# CITY OF ALBUQUERQUE

September 6, 2021

**Re: US Eagle Credit Union - Academy**  
**5420 Academy Road NE**  
**Traffic Circulation Layout**  
Engineer's Stamp 09-03-2021 (E18-D046)

Issue Date: 09/03/2021
Architect: B. Bily
Drawn By: PS
Checked By: MS
Project Number: 29643-0003
Title: **SITE PLAN**
Sheet No. **C-100**

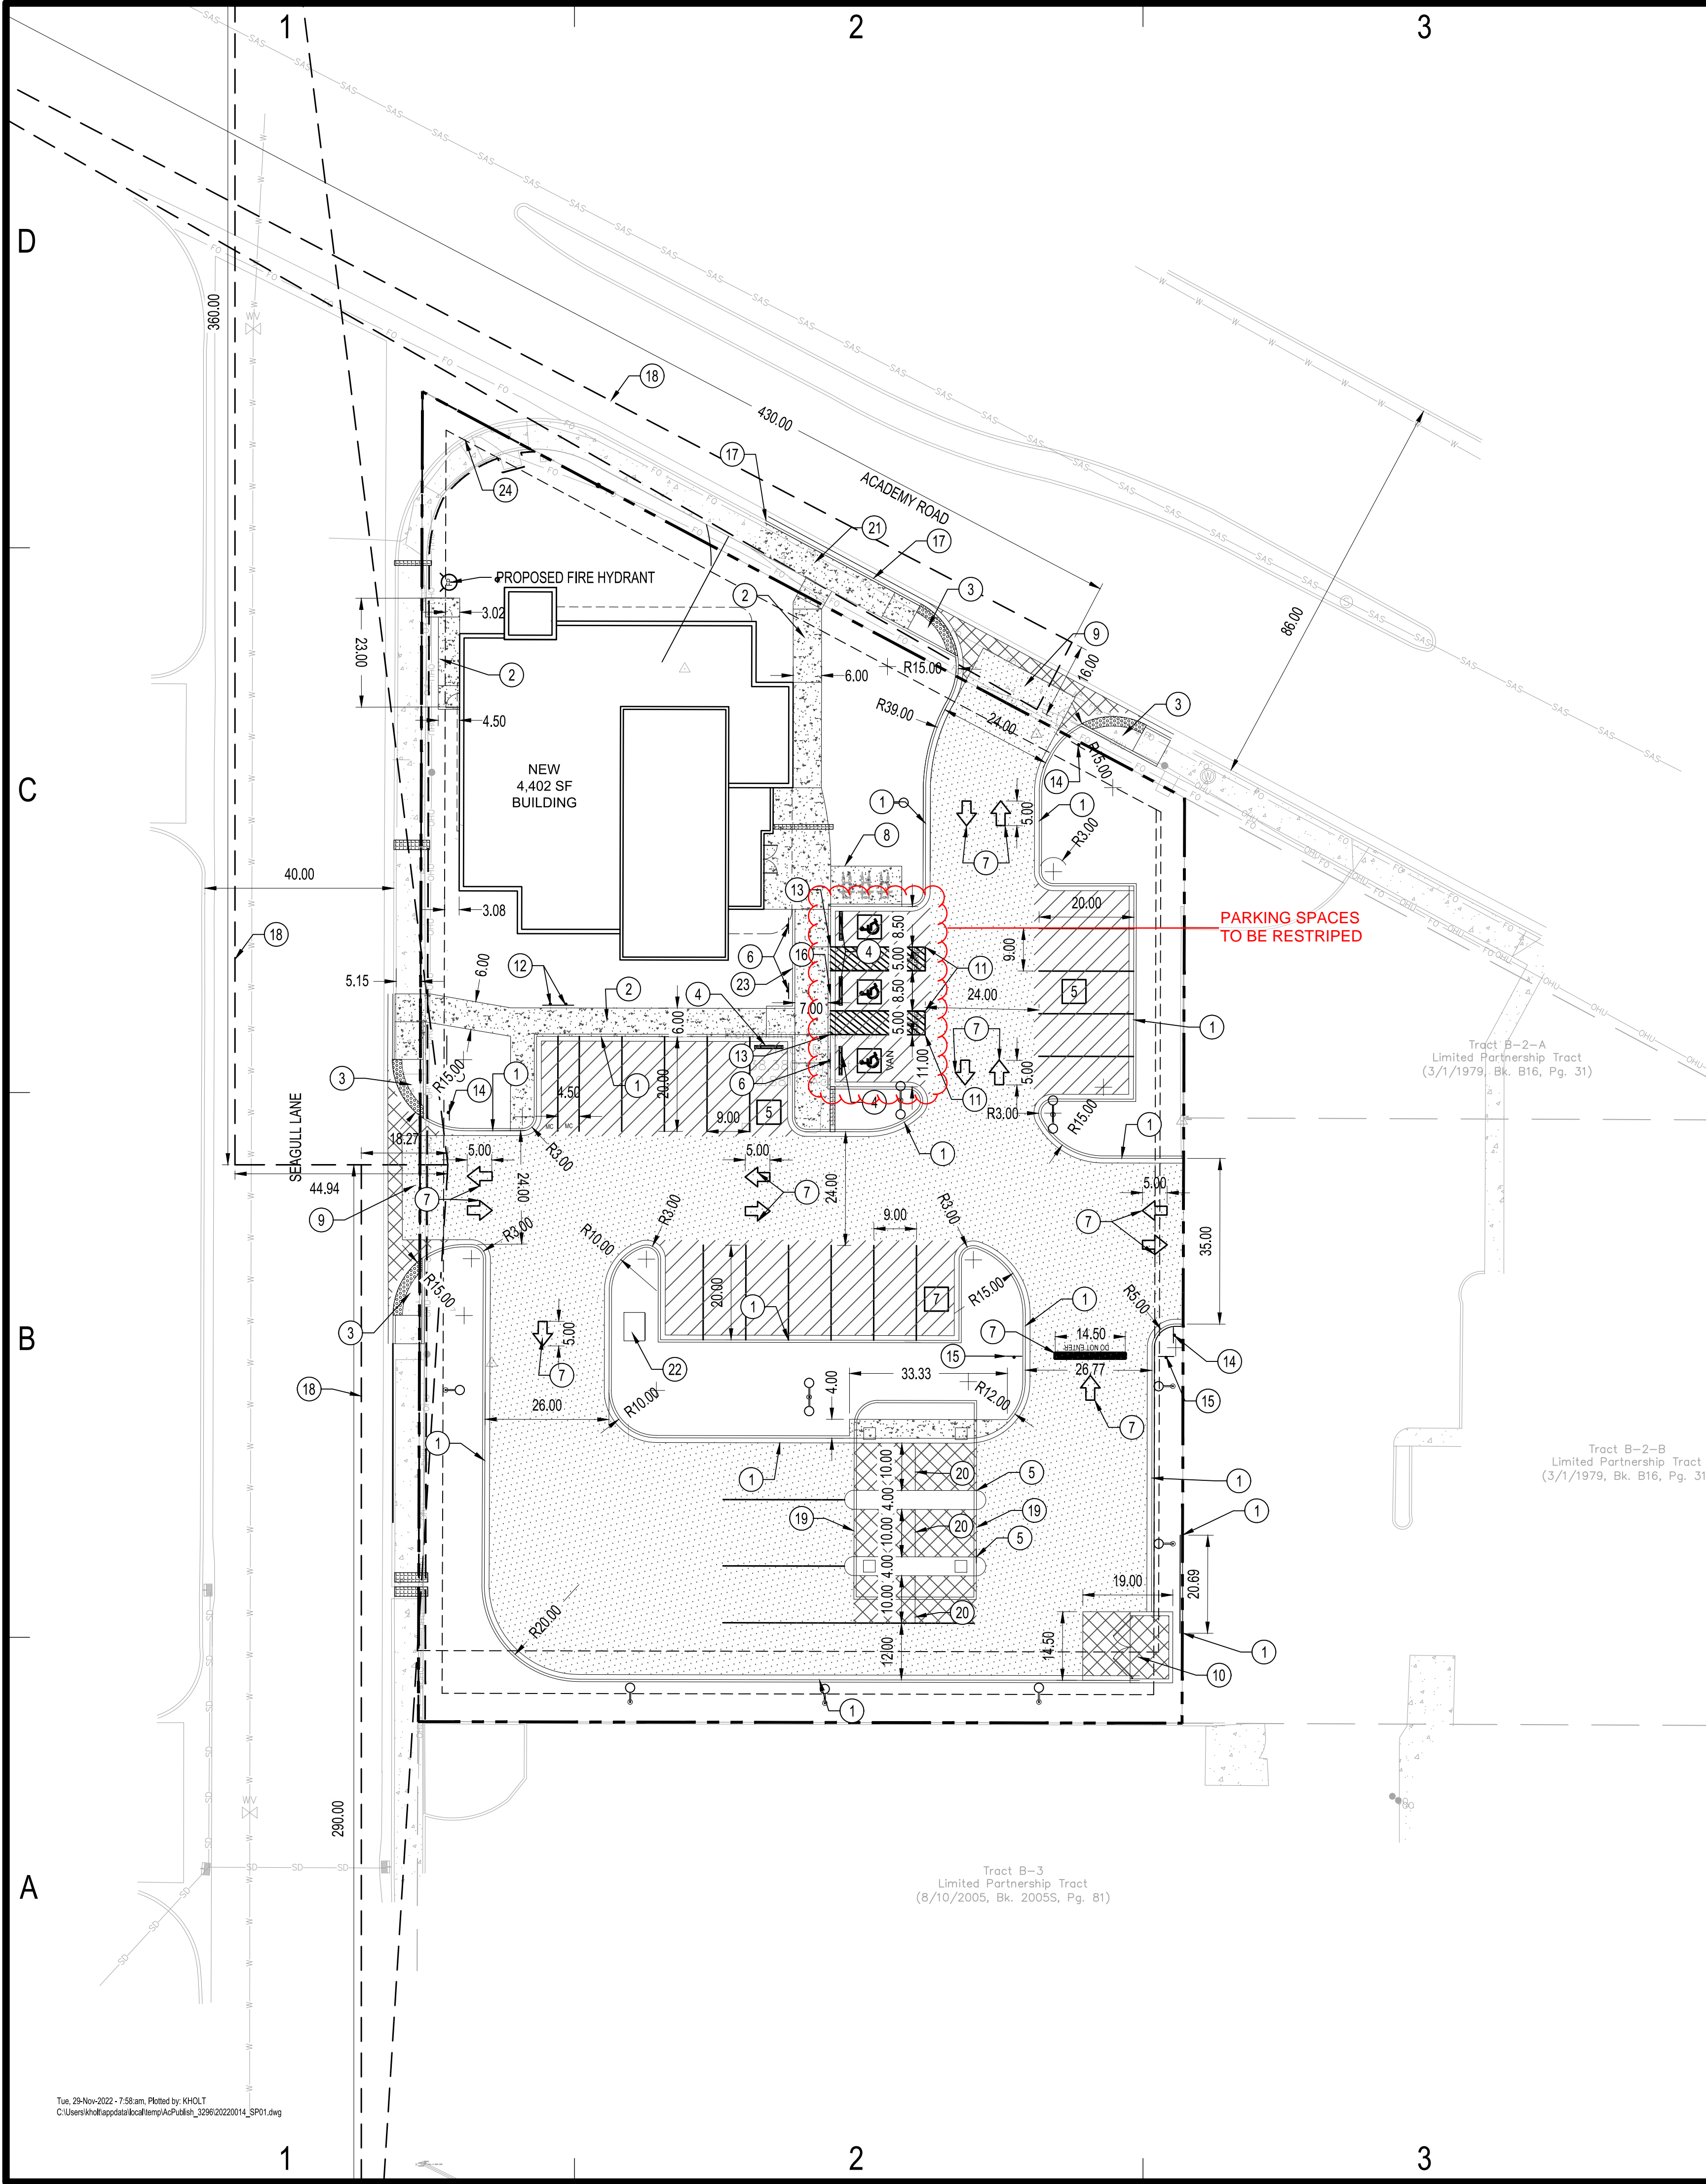
**Coordinate/discuss with Zoning.**
2. **Seagull Lane not Seagull Street.** Please adjust Site Plan.
3. **Academy/Seagull Corner:**
  - Due to sight distance concerns and to construct sufficient curb ramps, right-of-way dedication is required to add curves to corners of properties at intersections if they are not already developed. See Table 23.3 of the DPM.

- Or provide a sidewalk easement at this corner.
  - Existing Ramp: The ramp will need to be current/updated ADA and if it isn't then you will need to provide ramp and detail per COA std dwg.

4. Proposed driveways off Academy and Seagull will need construction notes for private entrances. **Suggest COA std dwg 2426.**
5. **Keyed Note 1 (Detail 4/C-101):** You call out 6" c&G but you show 8" on detail dimension. Please adjust detail.

6. **Keyed Note 2:** Provide the proposed sidewalk width coming off Seagull.
7. **Keyed Note 3 (Detail 9 Sheet C-101):** Add/reference COA std dwg 2426 or 2446.

8. **Keyed Note 7:** You will need to provide details for proposed pavement markings.
9. **Keyed Note 9 is being used as a label for pavement marking on drive aisle adjacent to propose ADA parking stall.** Please adjust this concern

10. **Keyed Note 10: You are referencing Architectual Plans.** So, either add this sheet to TCL project or add Dumpster enclosure and gate infrastructure to your detail sheets.

12. **Keyed Note 14 (Proposed Stop Sign):** Sign placement will need to be located on private property and not on COA ROW.
13. **Keyed Note 15 (Do Not Enter Sign):** The sign needs to be on both sides of the existing drive aisle.
14. Identify the right of way width, medians, curb cuts, and street widths on **Seagull Lane and Academy Road.**
15. The minimum parking stall dimensions are:

16. Since you are proposing a transition from C&G to flush, where is the proposed ramp? And the construction notes/details?
17. The ADA accessible spaces must include an access aisle. **Van accessible aisles should be 8ft wide;** all others should be 5ft wide.
18. The ADA accessible parking sign must have the required language per 66-7-352.4C NMSA 1978 **"Violators Are Subject to a Fine and/or Towing."** Please call out detail and location of signs.
19. The ADA access aisles shall have the words **"NO PARKING"** in capital letters, each of which shall be at least one foot high and at least two inches wide, placed at the rear of the parking space so as to be close to where an adjacent vehicle's rear tire would be placed. (66-1-4.1.B NMSA 1978)

26. Per DPM, a 6 ft. wide ADA accessible pedestrian pathway is required from the ADA parking stall access aisles to the building entrances. **Please clearly show this pathway and provide details. Other words provide sidewalk dimension in front of proposed ADA parking stalls.**

27. **The clear sight triangles (11'x11') will need to be shown on Seagull Lane.**
28. **Shown are the clear sight triangle and add the following note to the plan:**  
"Landscaping and signage will not interfere with clear sight requirements. Therefore, signs, walls, trees, and shrubbery between 3 and 8 feet tall (as measured from the gutter pan) will not be acceptable in the clear sight triangle."

31. How will this proposed development obtain water/sewage etc...? Water Authority mini work order? Explain/address.
32. On Note "All broken or cracked sidewalk must be replaced with sidewalk and curb & gutter." **A build note must be provided referring to the appropriate City Standard drawing (2430 & 2415A).**
